El Paso County
STORMWATER MANAGEMENT PLAN

Short Stop Restaurant
Part of Lot 1, Powers Centre Filing No. 3
Section 6, Township 14 South, Range 65 West of the 6th P.M.
5819 Palmer Park Boulevard

October 2, 2018

SUBJECT: Stormwater Management Plan
Short Stop Restaurant

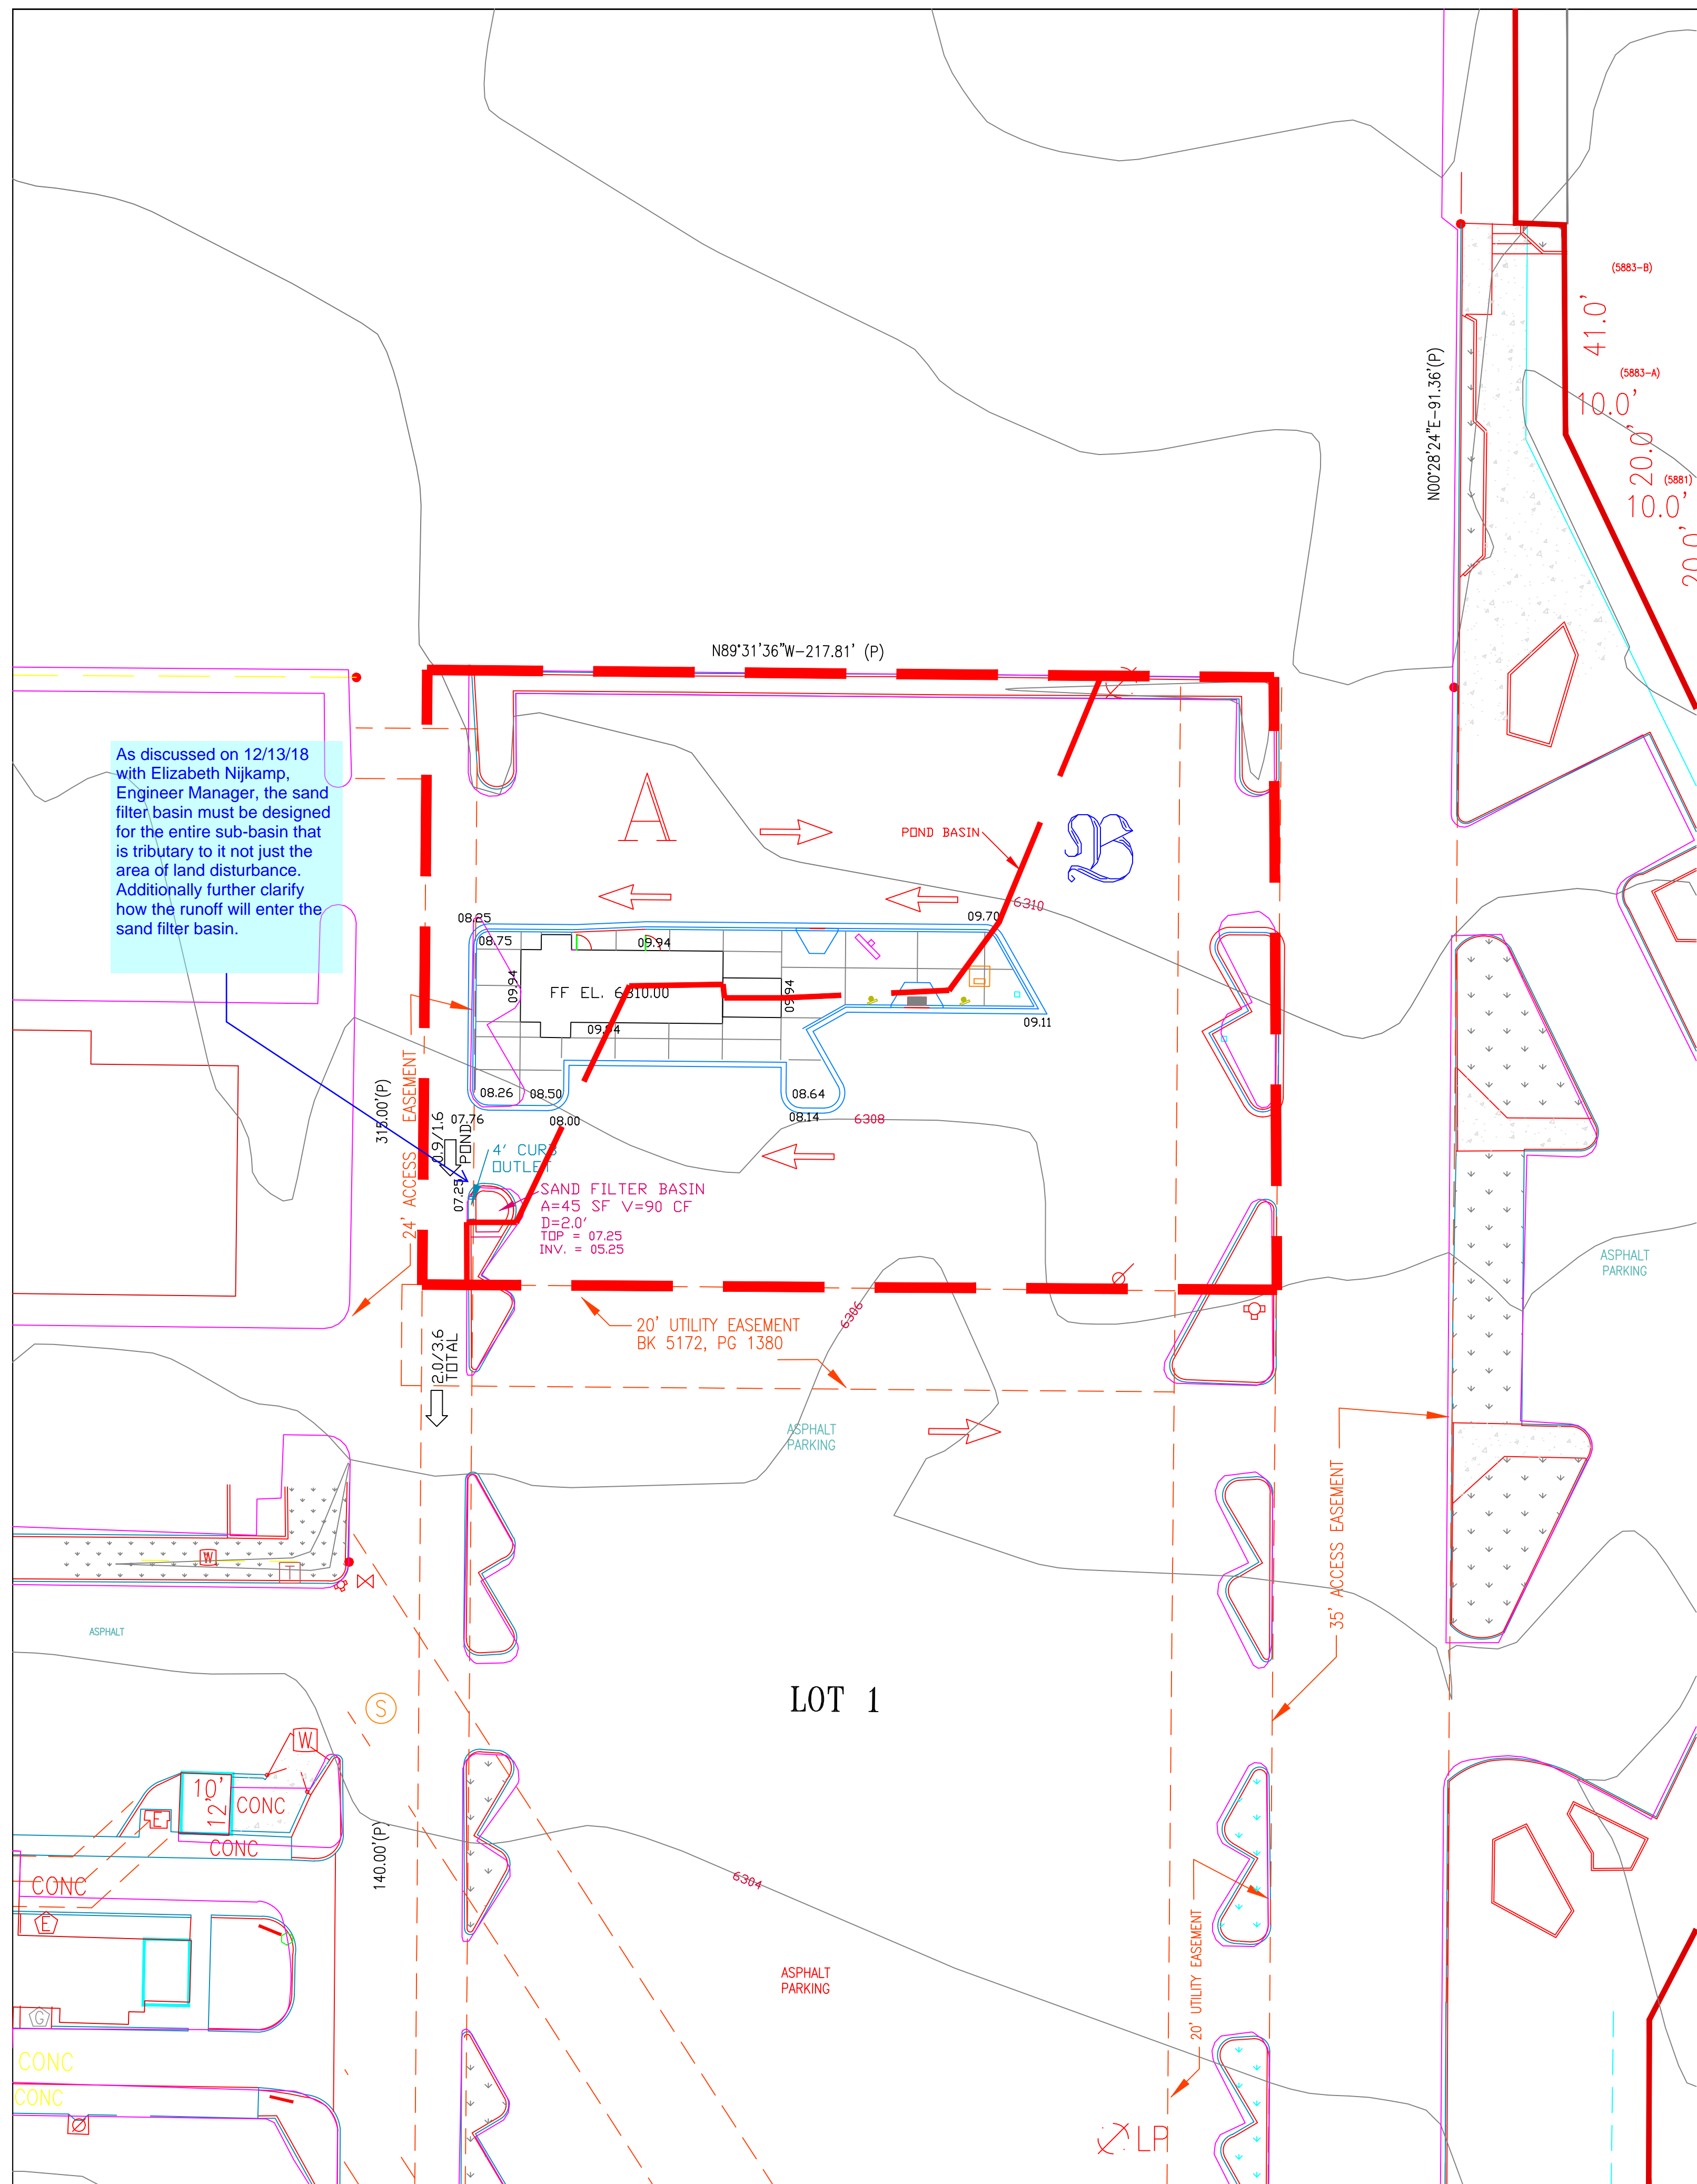
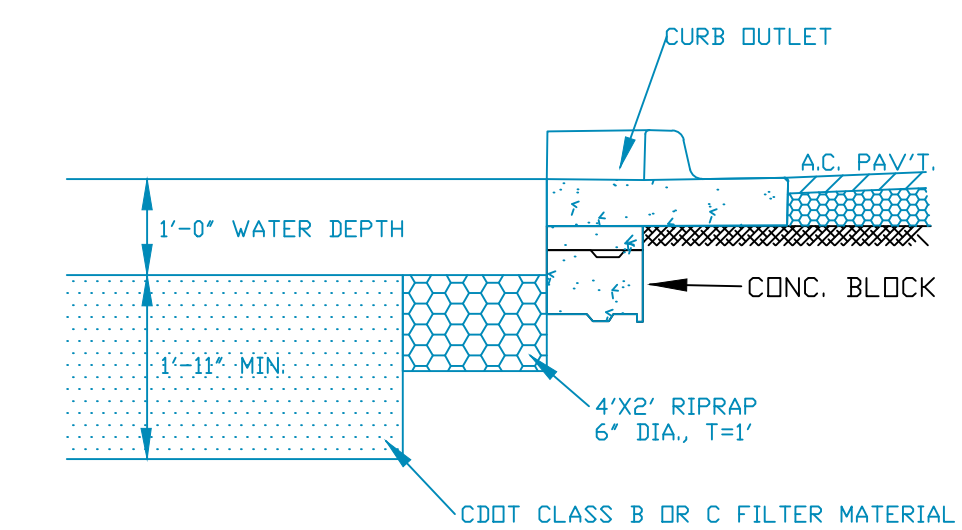
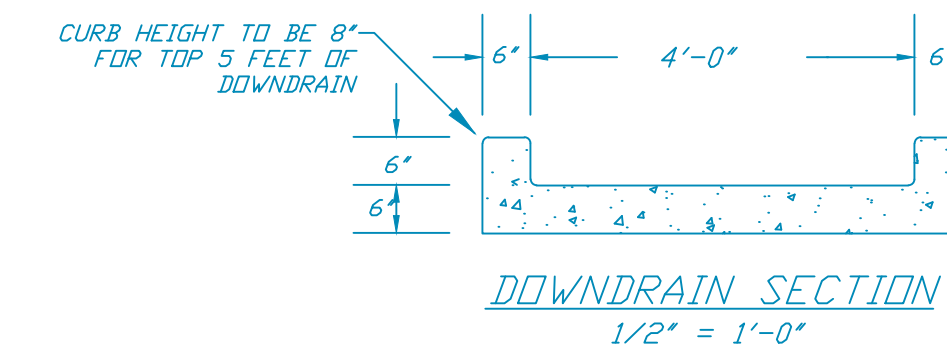
Provide details
